Access for People with a Disability

**Access Strategy Review
December 2010**

Abercrombie Precinct Redevelopment

Project Name: Abercrombie Precinct
Project Number: A10113

Drawing title
PLAN - UPPER CARPARK LEVEL

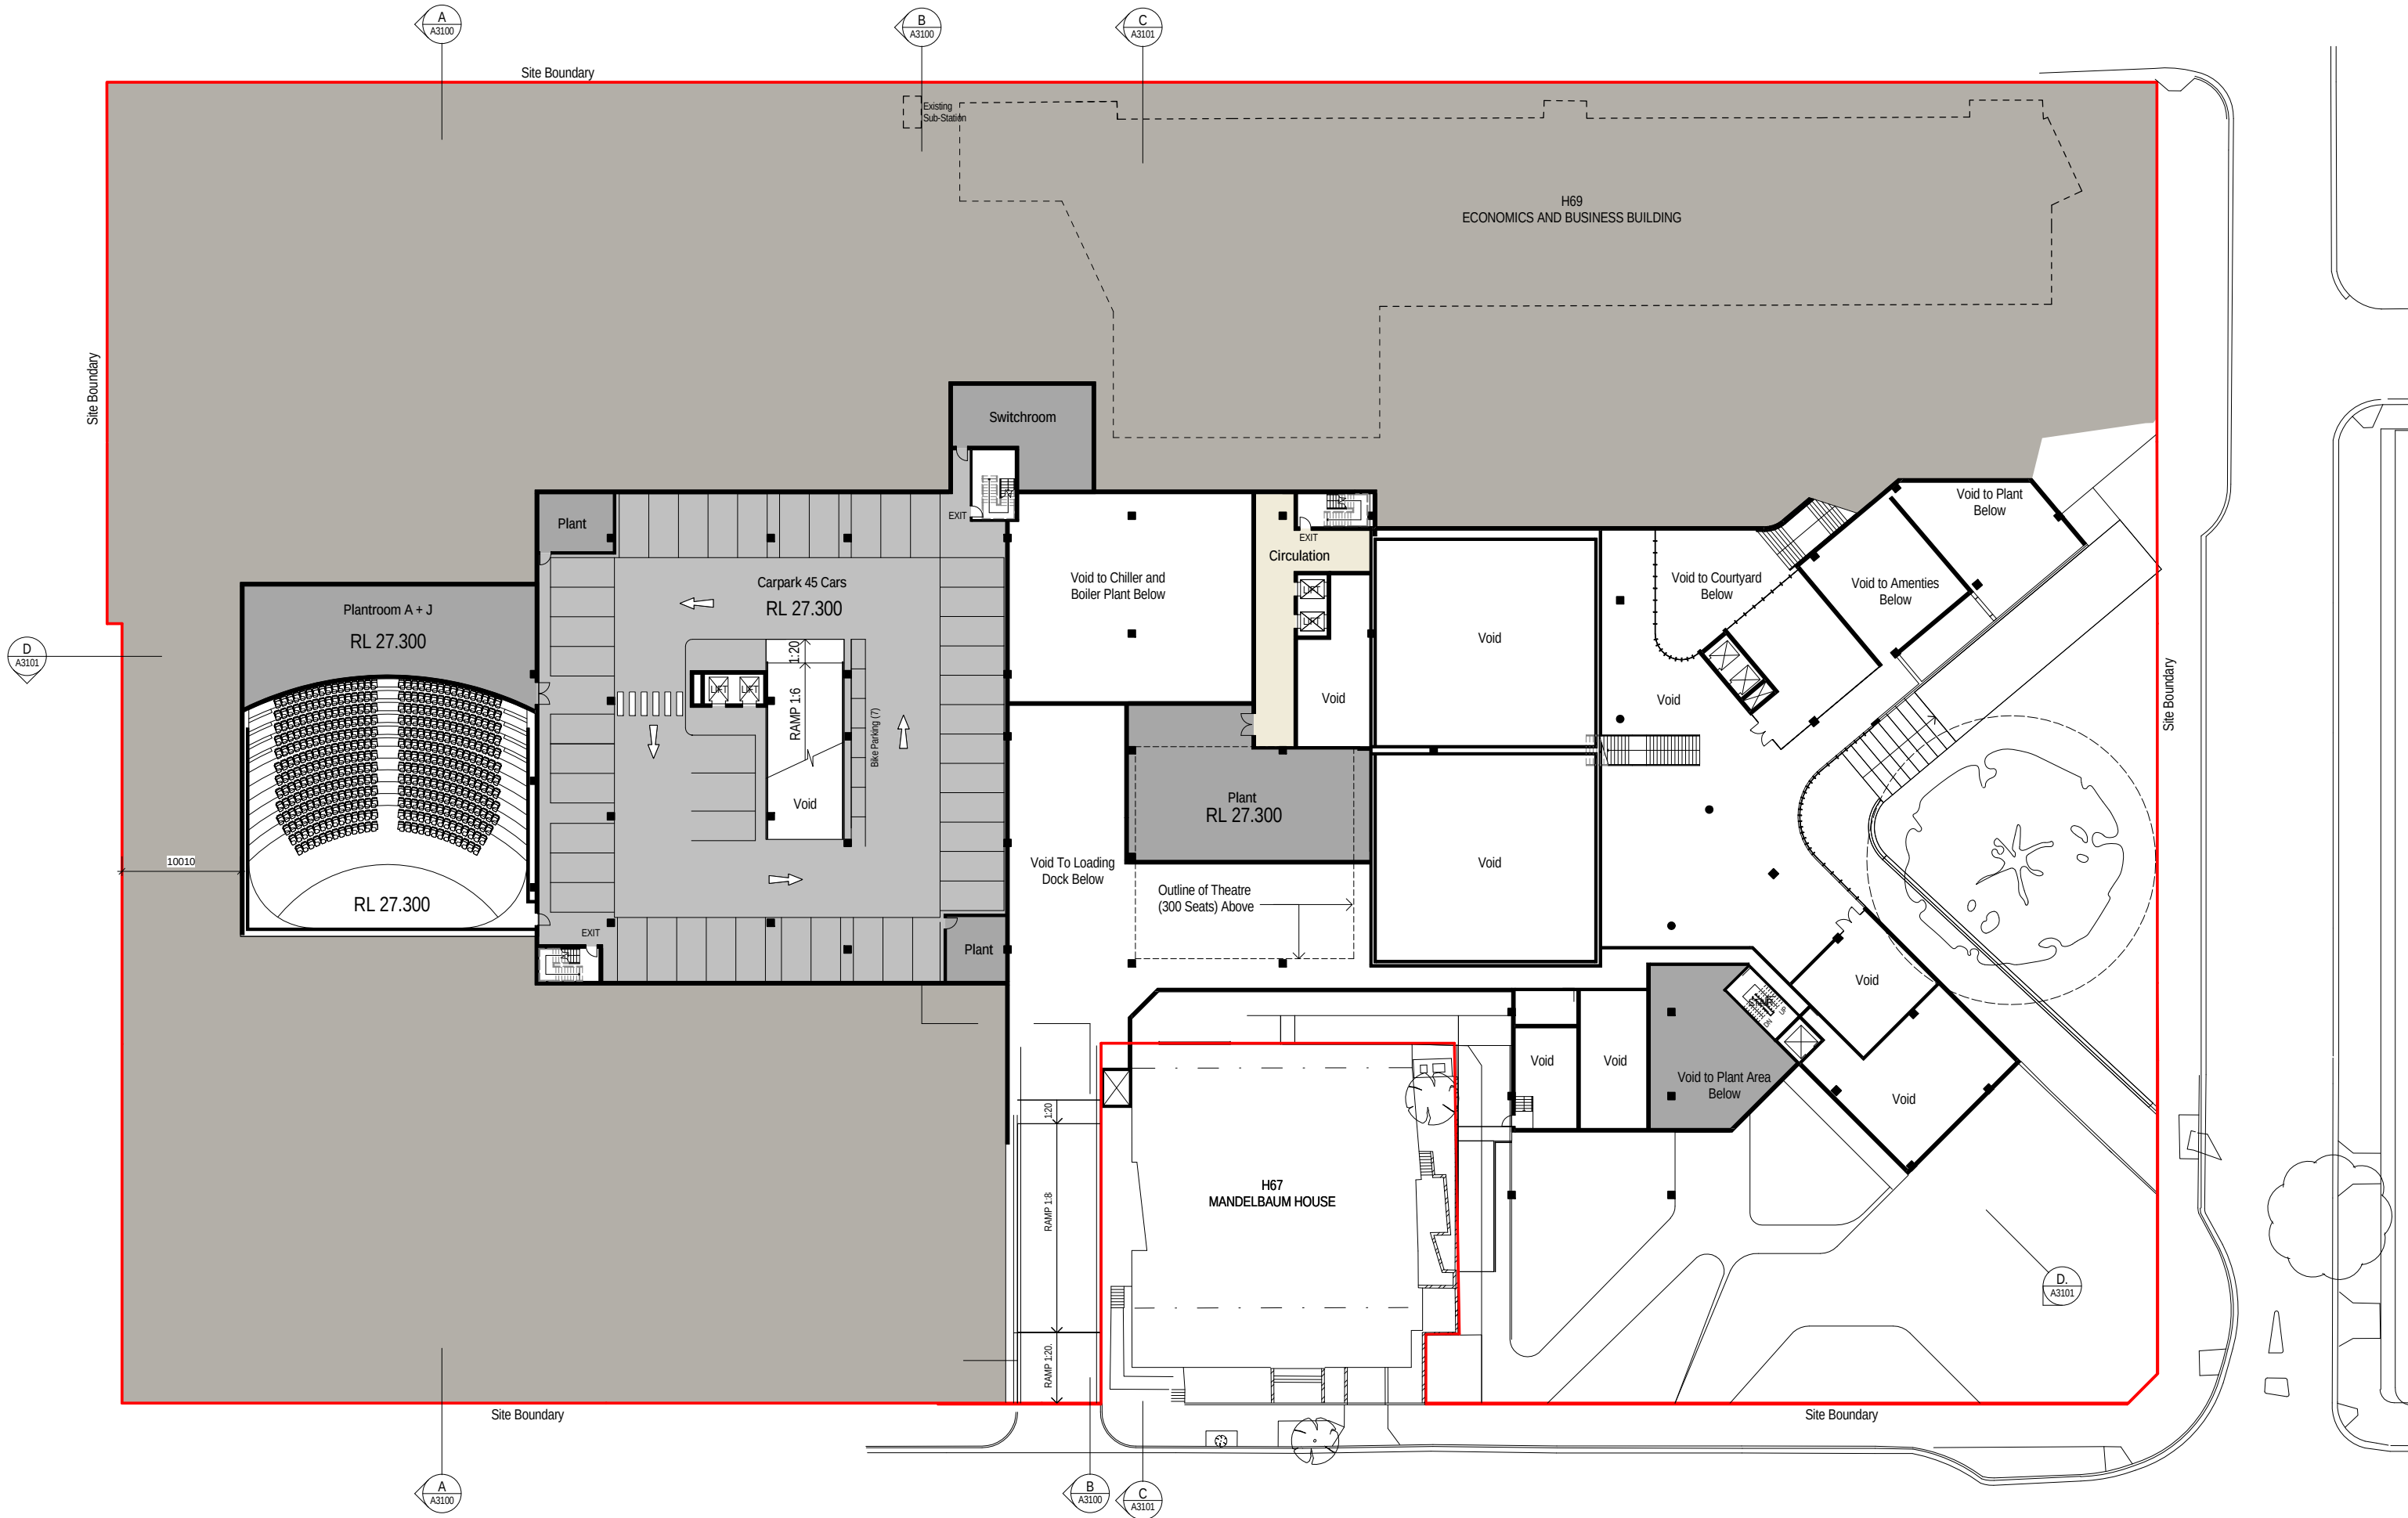
- (i) Ensure in ongoing design the accessible parking spaces are provided to meet the BCA D3.5 and DDA requirements and include dimensions and a layout to meet the requirements of AS2890.6 (2009) figure 2.3 (car space dimensions: W: non shared 2.4m + shared 2.4m (min 4.8m); L: non shared 5.4m + shared 2.4m; height 2.5m over the accessible space and share area and 2.2m on the path of travel to the space).
